Please upload the email from the applicant below and the attached revised plans onto Ocella for BE/135/18/PL – Salt Box.

Network 3 Unit 1-9

SAL-HYD-00-ZZ-CA-C-0003 - Network 3 / SAL-HYD-00-ZZ-SK-C-7900 P03

HYDROCK PROJECT NO.	SCALE @ A1
C-13319-C	1:500
STATUS DESCRIPTION	STATUS
INFORMATION	S2
DRAWING NO. (PROJECT CODE-ORIGINATOR-ZONE-LEVEL-TYPE-ROLE-NUMBER)	REVISION
SAL-HYD-00-ZZ-SK-C-7900	P02

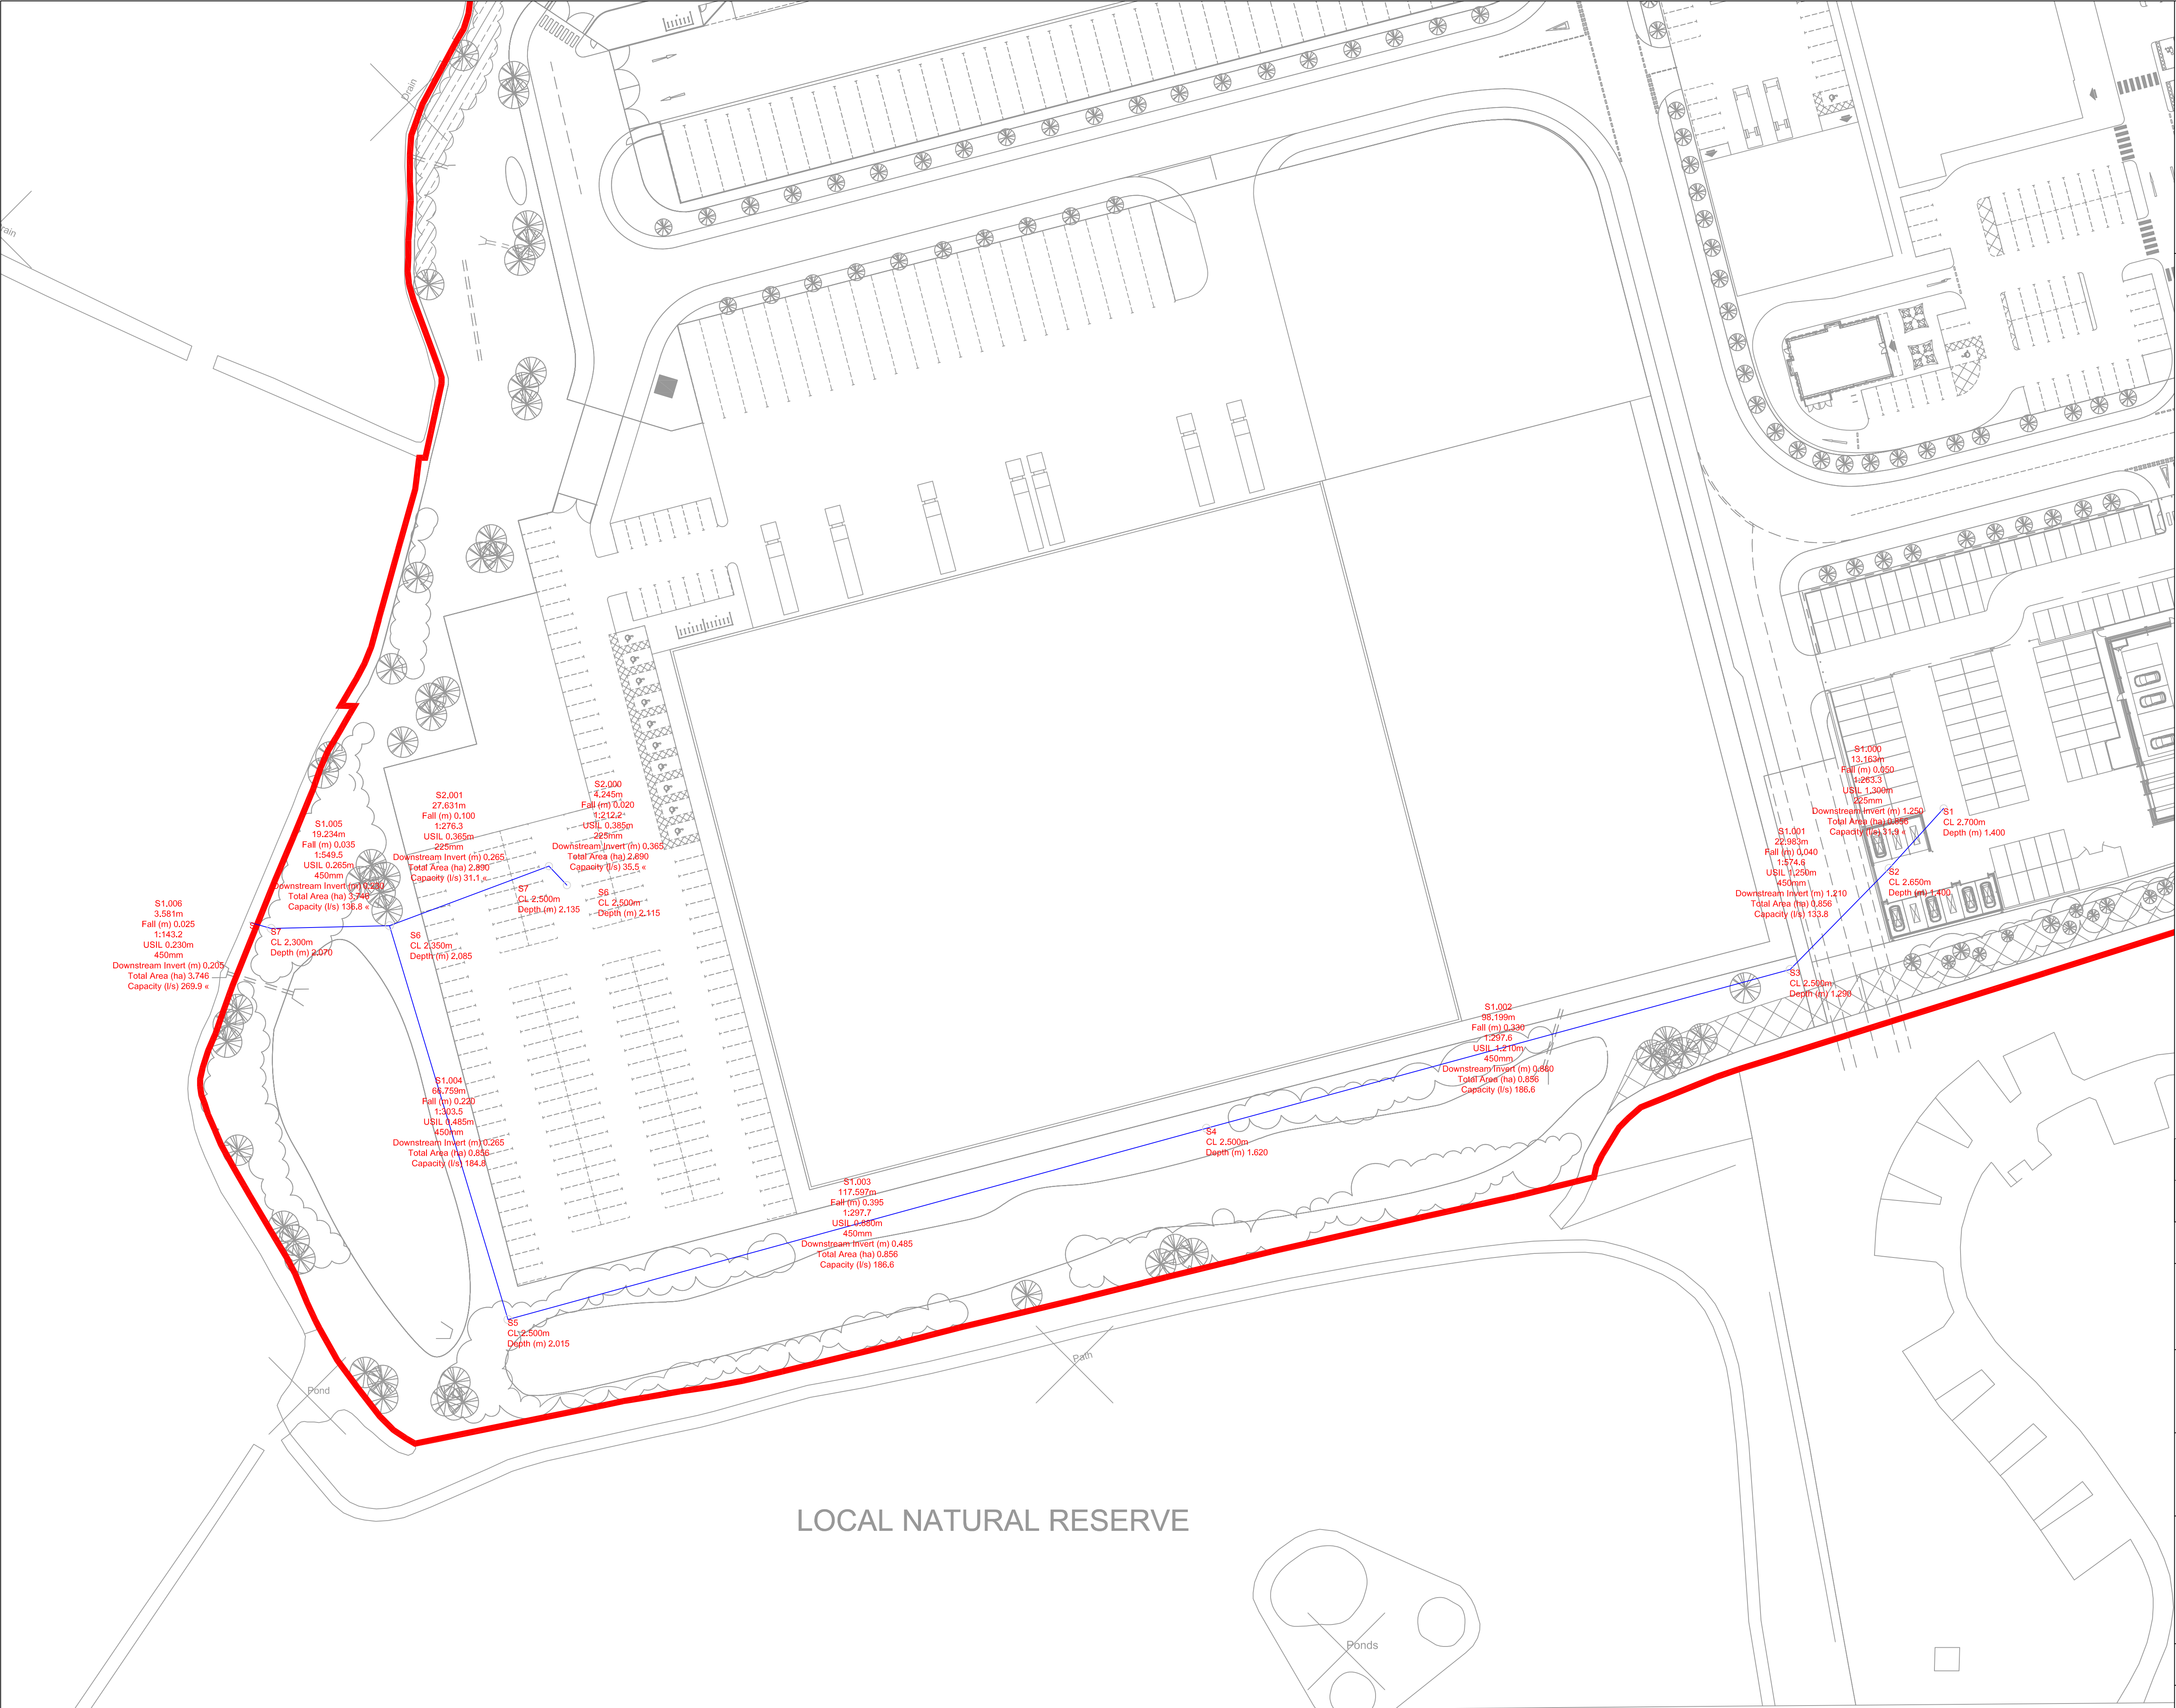
I note from SAL-HYD-00-ZZ-SK-C-7900_P02.PDF that you have raised the cover levels of S1 – S6 to above the 1.85m flood level. However, the other S6 & S7 (on network refs S2.000 & S2.001 have similarly been raised but they are within the car park – is this whole area to be raised – in which will this not affect the compensation calculations?

- We have now moved the drainage runs S3-S5 into the hardstanding just outside Unit 1 to suit levels.
- Car park levels have not changed, the first Drawnet model had not updated to the required flood compensation levels, apologies for the confusion here.
- All levels around Unit 1 and car park are above the flood compensation and have been considered in the model. Cover levels should now reflect this.

Following culvert update and change to S3-S5 location drawings SAL-HYD-00-ZZ-SK-C-7900 and SAL-HYD-00-ZZ-DR-C-7020-7020 have also been updated.
